Our ref: RA/2025/148334/02-L01
Your ref: 2025/90508

Date: 15 October 2025

ERECTION OF CANOPY TO EXISTING YARD AND EXTENSION TO EXISTING EXTERNAL STORAGE YARD (AMENDED PLANS/DOCUMENTS SUBMITTED). PO BOX 521, LEEDS ROAD, HUDDERSFIELD, HD2 1YU

PROPOSED SITE LAYOUT

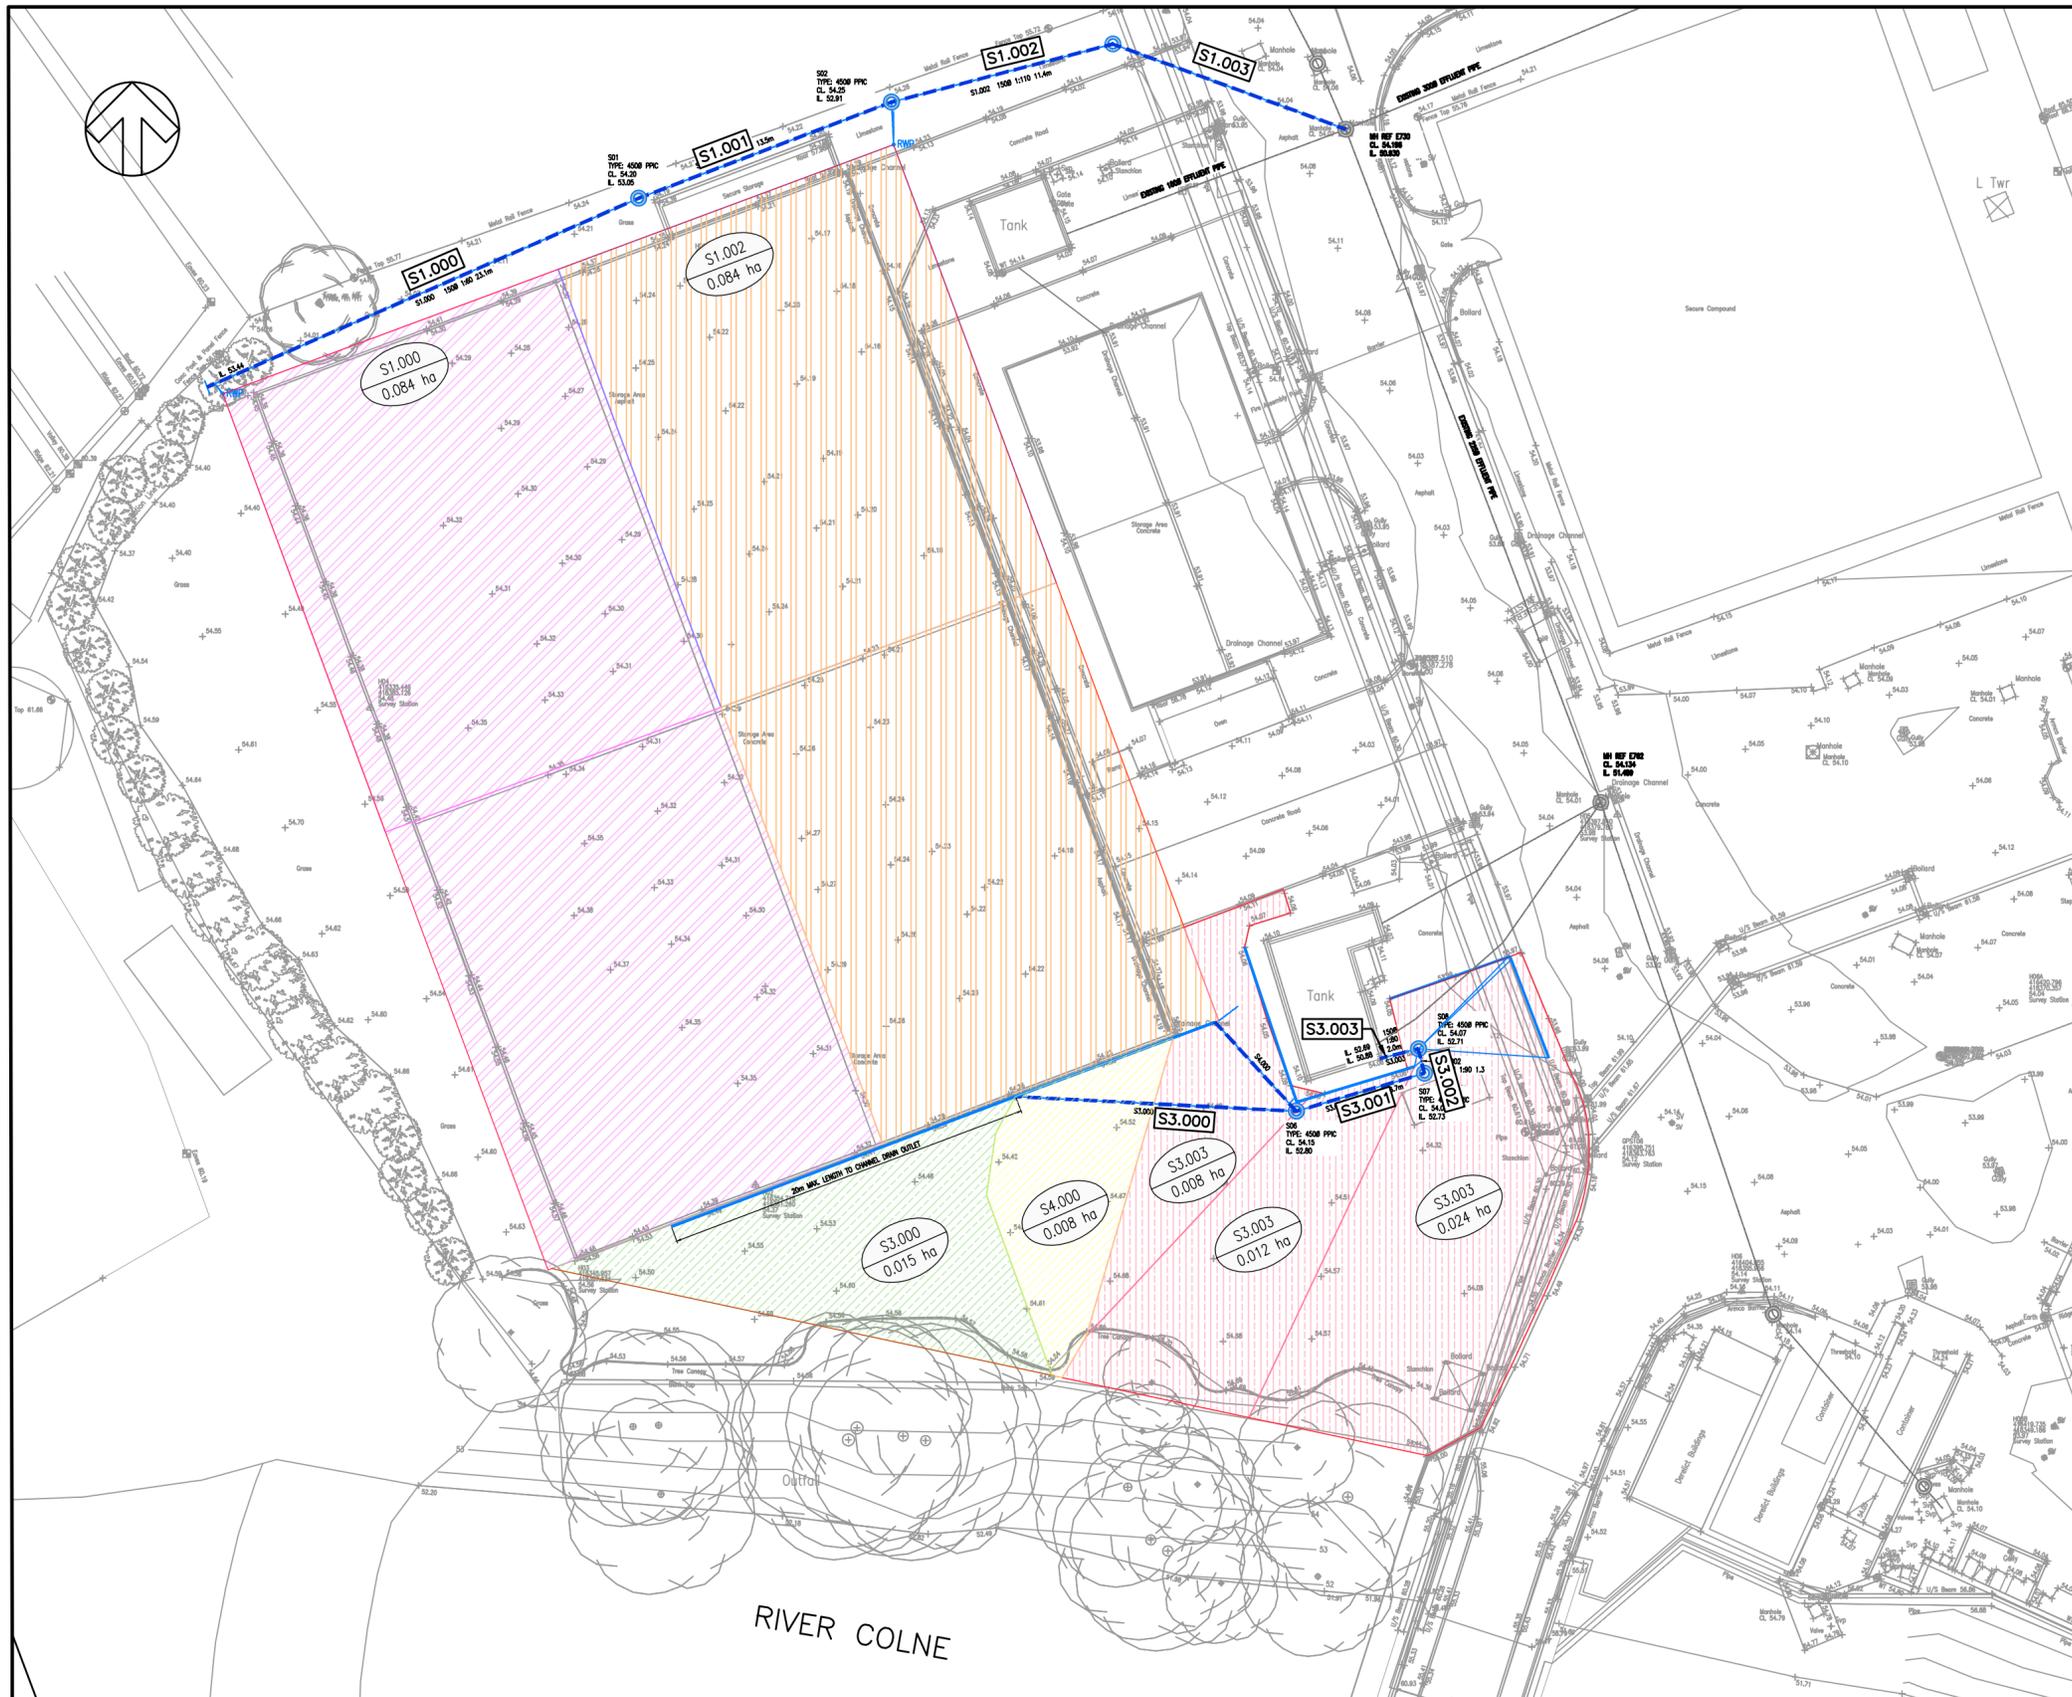
The 'Proposed Site Plan, Ref No: 0005 Rev: P06' shows the concrete yard is not within 10 metres of the bank which is what we requested in our previous objection. However, the canopy is shown to be within 8 metres of the watercourse and 8 metres from bank top. There is also a fence line shown on the plan that is on bank top and not shown on the 'Existing Site Plan Ref No 0003 Rev P03' so we are assuming this is a new fence and therefore part of the proposed development.

Should any proposed new fencing be planned within the 10 metre buffer area, this will be considered as built encroachment within the 10 metres and therefore a breach of this condition. Therefore, the fencing should be re-sited out of the buffer zone. If this cannot be achieved we ask to be consulted with a justification of why this needs to be sited within the 10 metres buffer zone if it cannot be moved.

- plans showing the extent and layout of the buffer zone
- details demonstrating how the buffer zone will be protected during development and managed over the longer term
- The canopy must not extend further than is shown on plan 'Proposed site plan – drawing no 0005 revision P06.'
